**Re: Major Project MP09_0154
Project Application for a mixed use commercial residential building at
7 Railway Street, Chatswood**

SUBMISSION TO DEPARTMENT OF PLANNING ON MPO9_0154 FOR A PROPOSED MIXED USE RESIDENTIAL COMMERCIAL BUILDING AT 7 RAILWAY STREET CHATSWOOD

PROPOSED BUILDING ENVELOPE

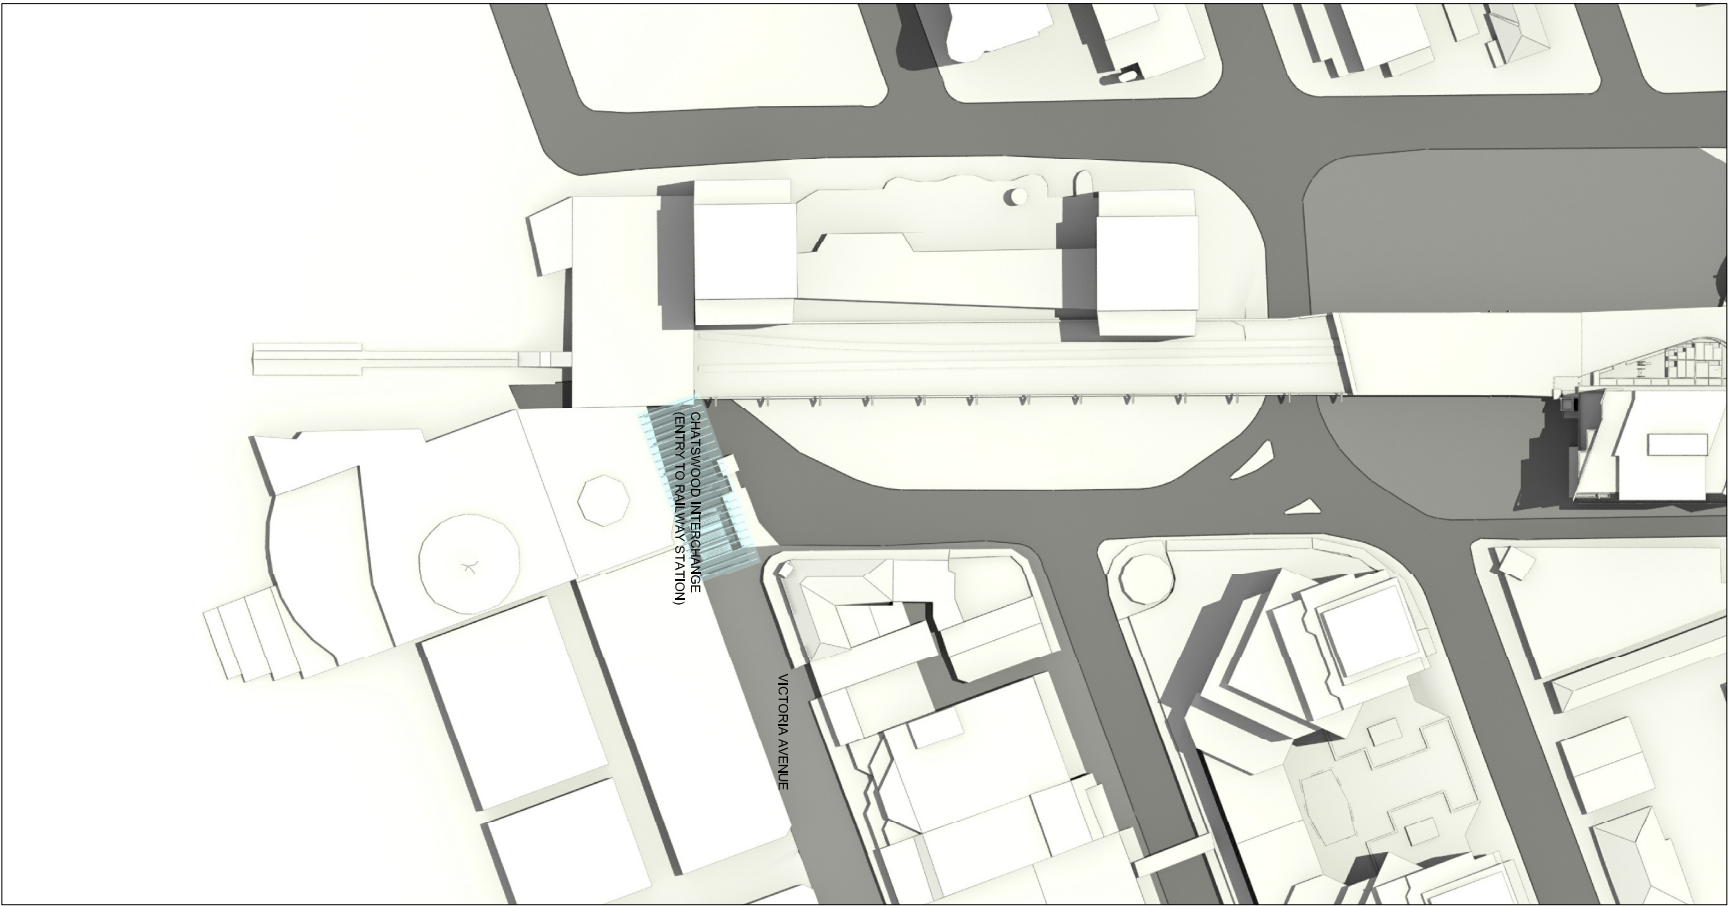
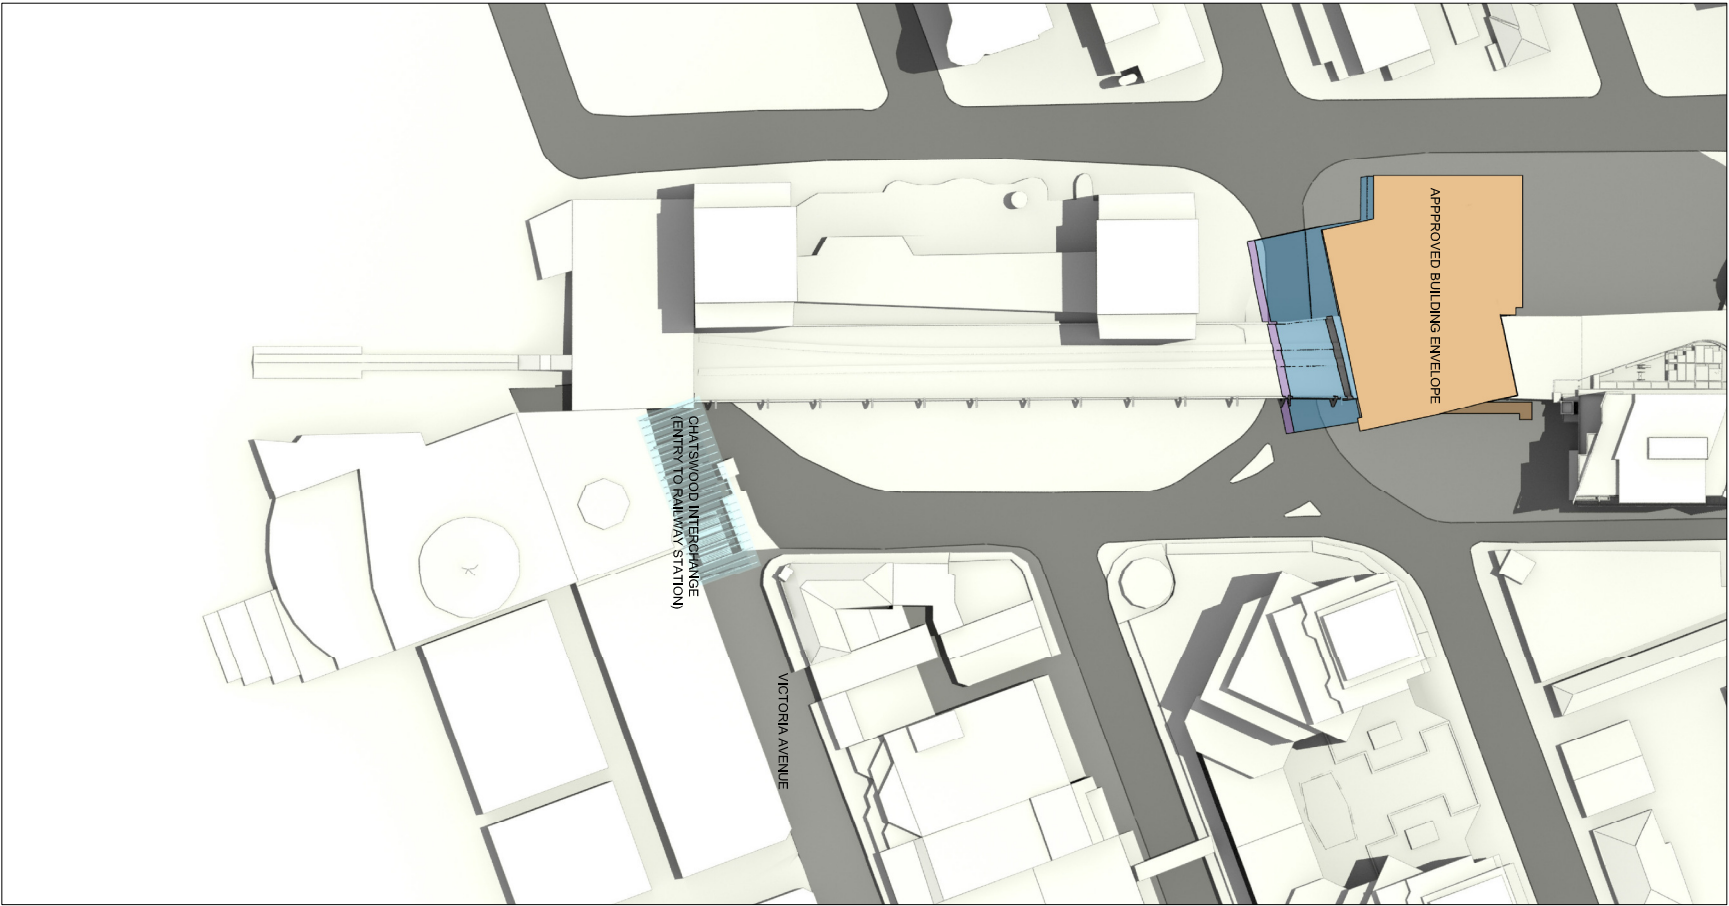
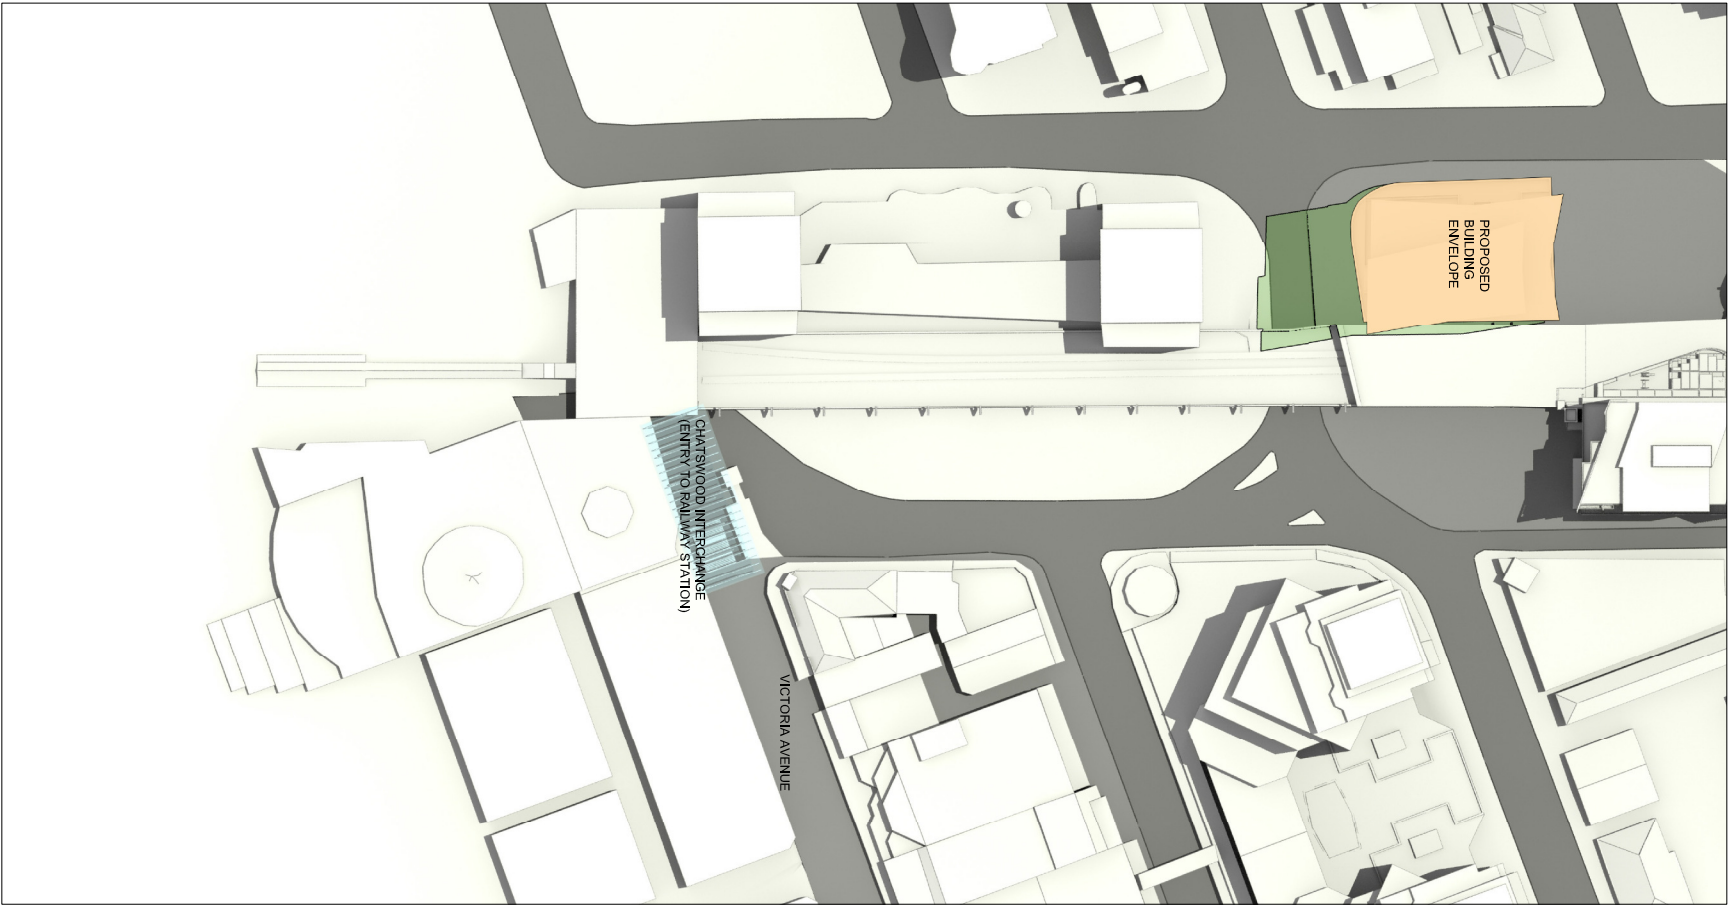
The Project Application exceeds the height control of RL 179AHD by about 52 metres or an additional 65% in the height of the building compared with the approved building on the site and the statutory controls of SREP5.
